# CITY OF ALBUQUERQUE

October 1, 2012

**Re: La Vista Subdivision Lots 9, 10 and 11, Grading and Drainage Plan  
Engineer's Stamp Date 9/25/2012 (C19/D042)**

**LA VISTA @ DESERT RIDGE SUBDIVISION  
GRADING AND DRAINAGE PLAN FOR LOTS 9,10 &11**

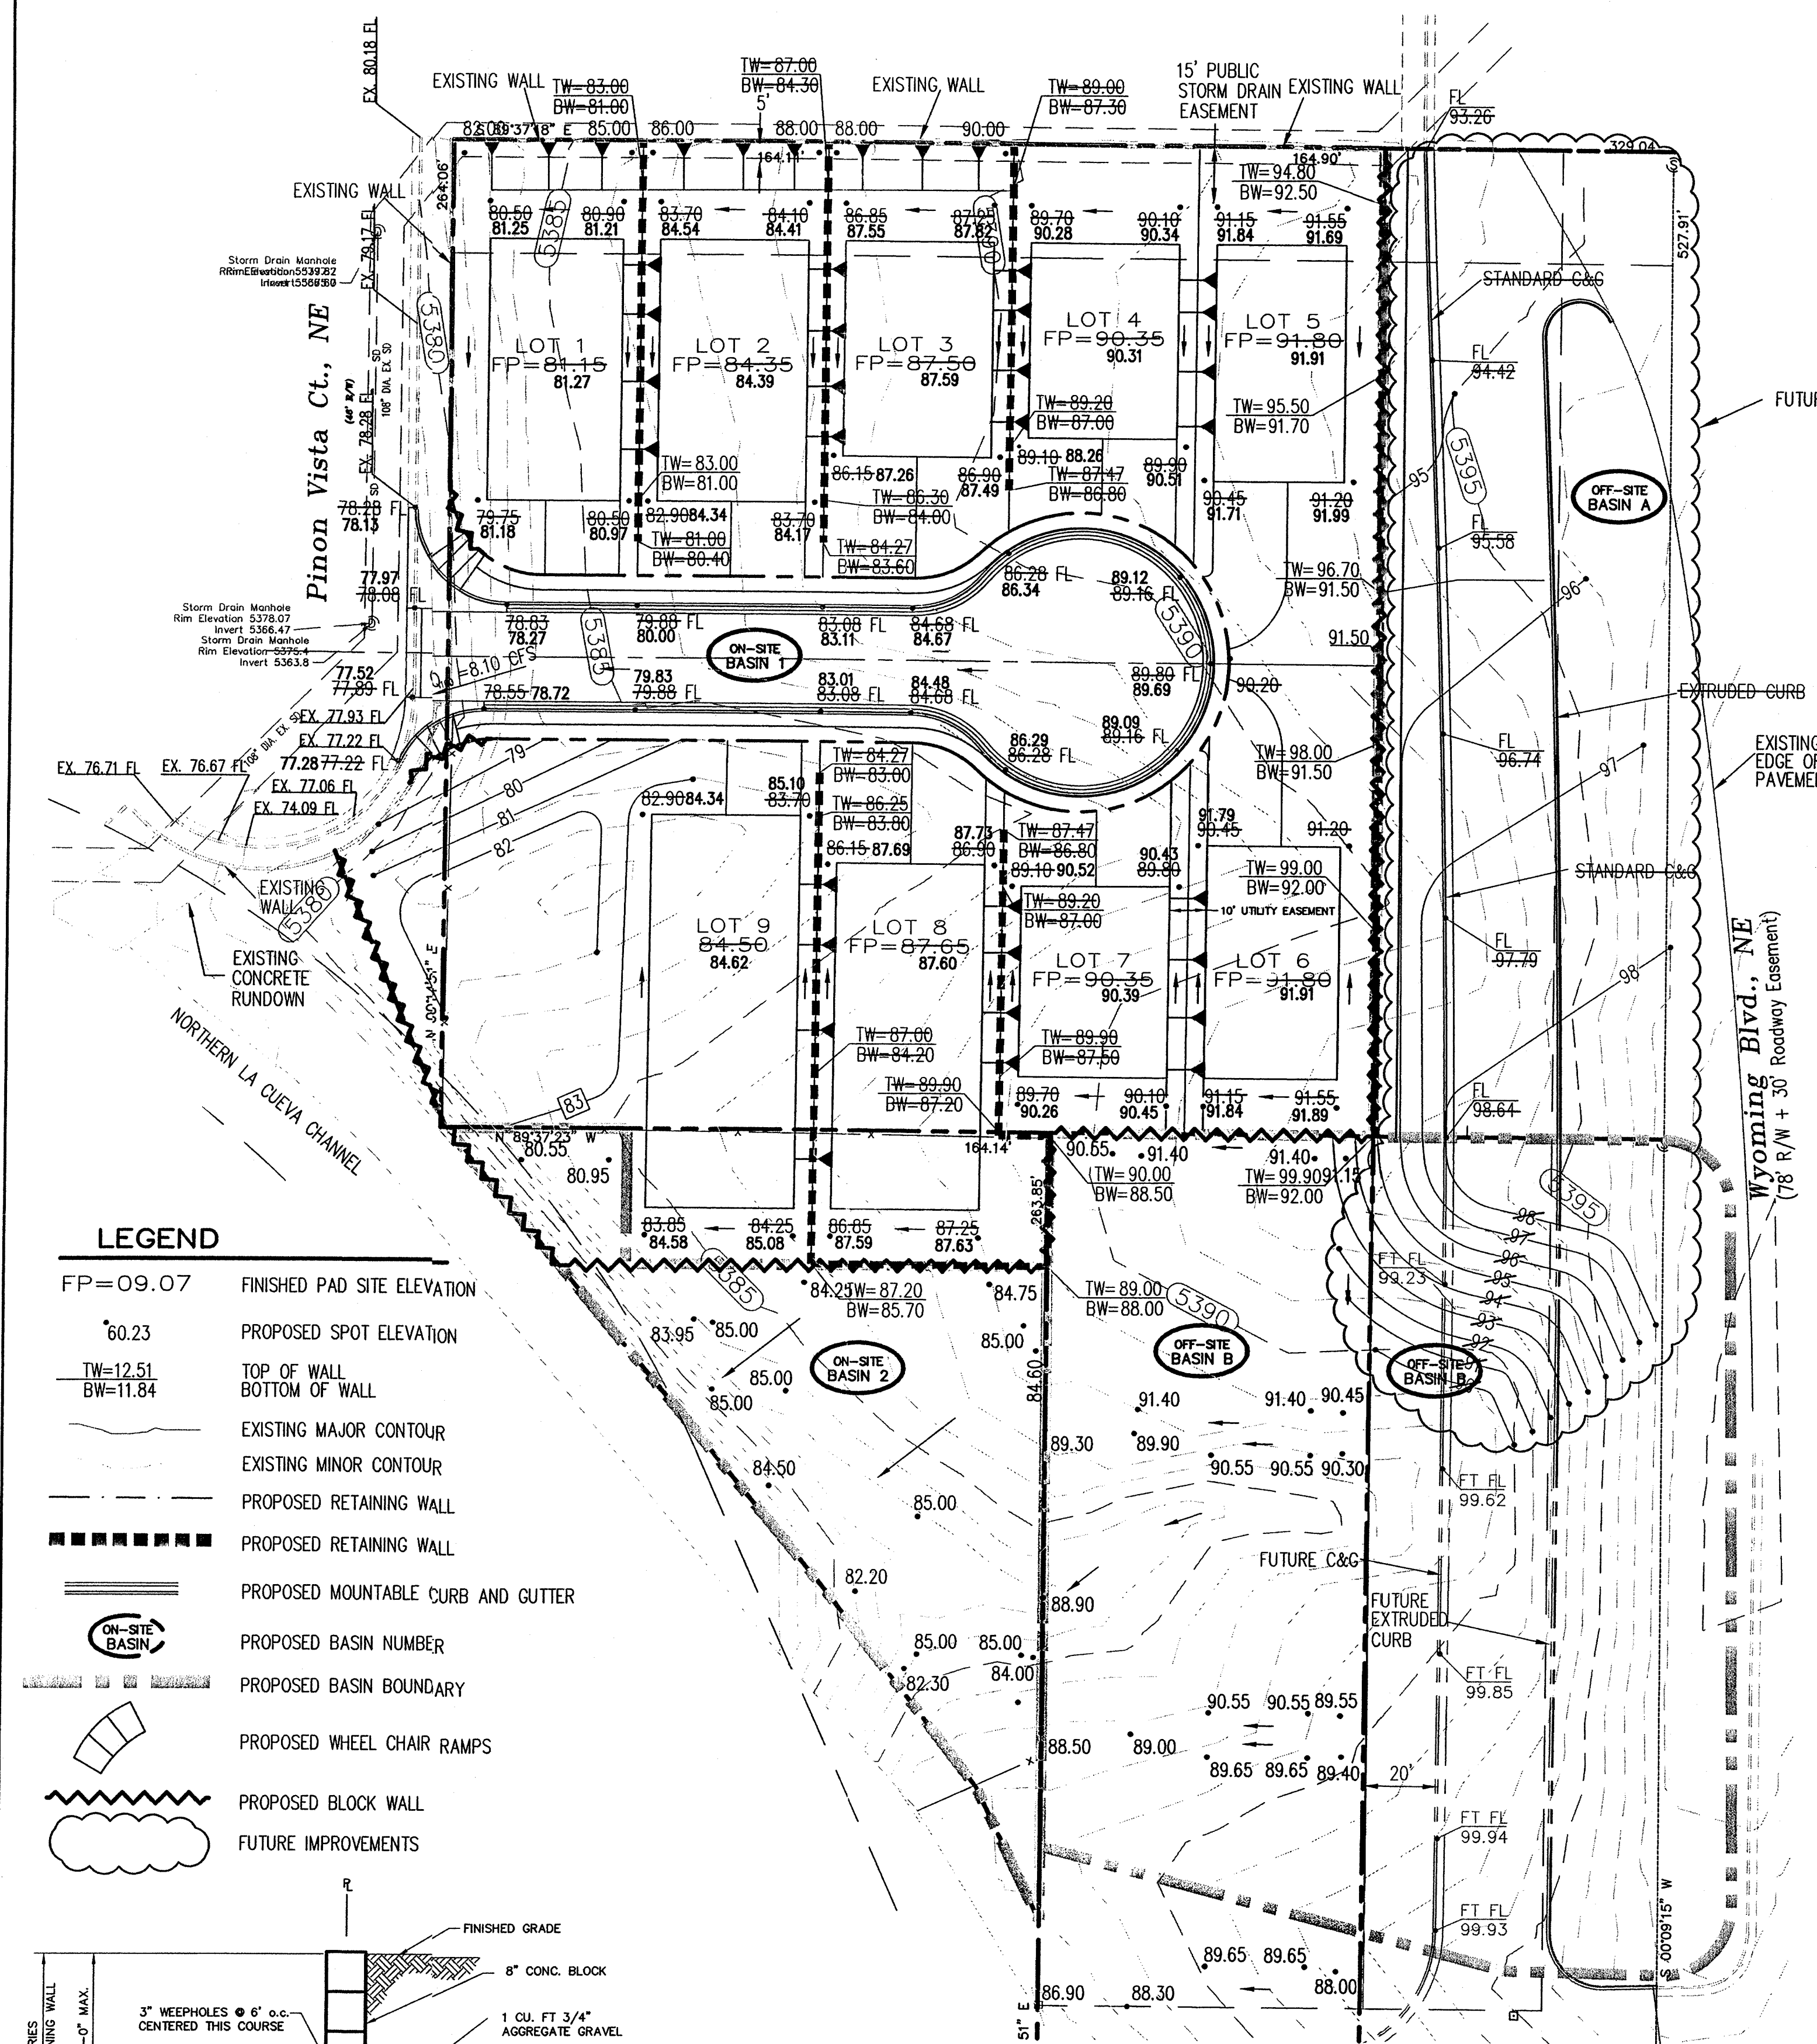
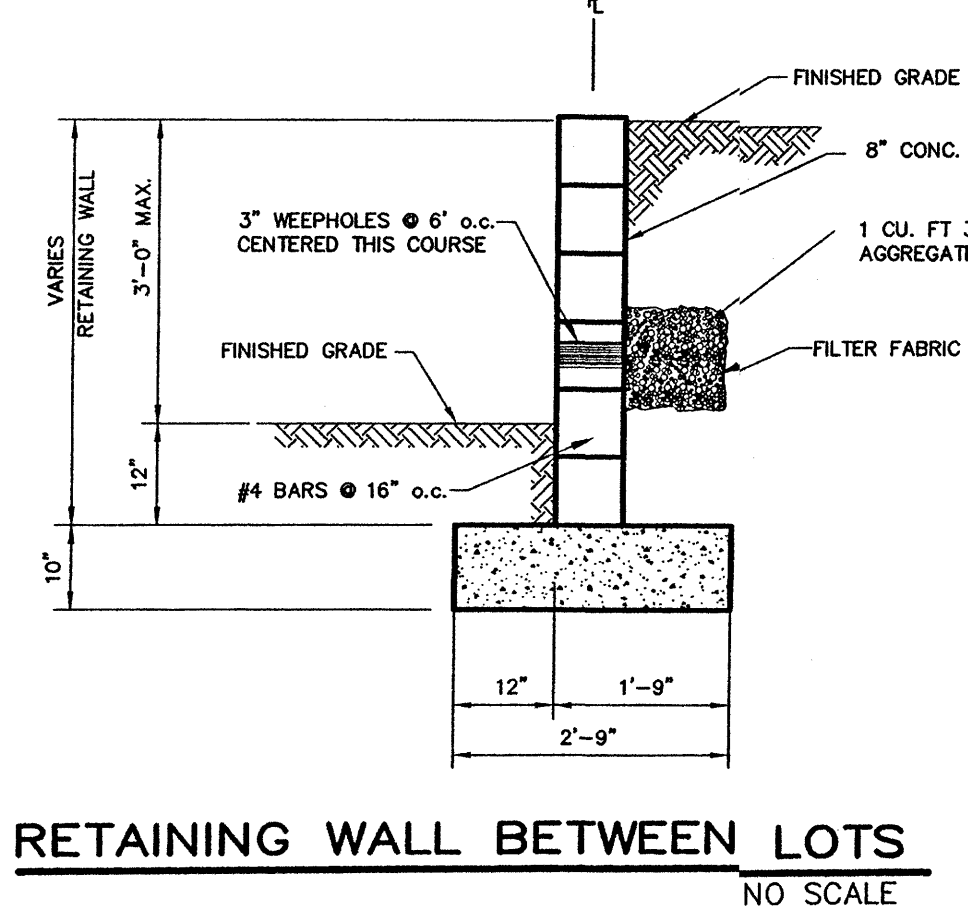
- Since this site drains to and is adjacent to an AMAFCA channel, AMAFCA approval is required.
- The proposed wall along the eastern edge of Lot 11 changes the existing drainage pattern for Lot 17. Lot 17 historically drained to the side inlet of the La Cueva Channel rather than "...toward Eagle Rock Ave" as stated in the drainage narrative. Demonstrate how Lot 17 could drain to Eagle Rock Ave, which does not have curb and gutter or Lot 17 should drain to the channel side inlet as it historically did.

- Lot 11 should drain to the channel side inlet.
- Existing contours should be in agreement with grades provided on your certification of La Vista @ Desert Ridge Subdivision dated 9-11-12.

- Provide existing grades in the AMAFCA ROW, including adjacent to Lot 11 and approximately 25 feet into the AMAFCA ROW.
- Why is there a low point (TW 88.30, 89.00 north and south of it) midway down the lot along the eastern side of Lot 11? Should the grade be 89.30?

- Show the La Cueva channel.
- Show the La Cueva channel side inlet with corner and invert grades.
- Please remove the "concrete channel" detail as it is not proposed.

- Remove Note 1 that mentions the builder will construct side yard retaining walls. The developer will construct the retaining walls as part of this grading plan.

- BW grades are in disagreement with grades on the low side of the wall for Lot 11.
- Why does the La Cueva Channel (dotted lines) run through this site?
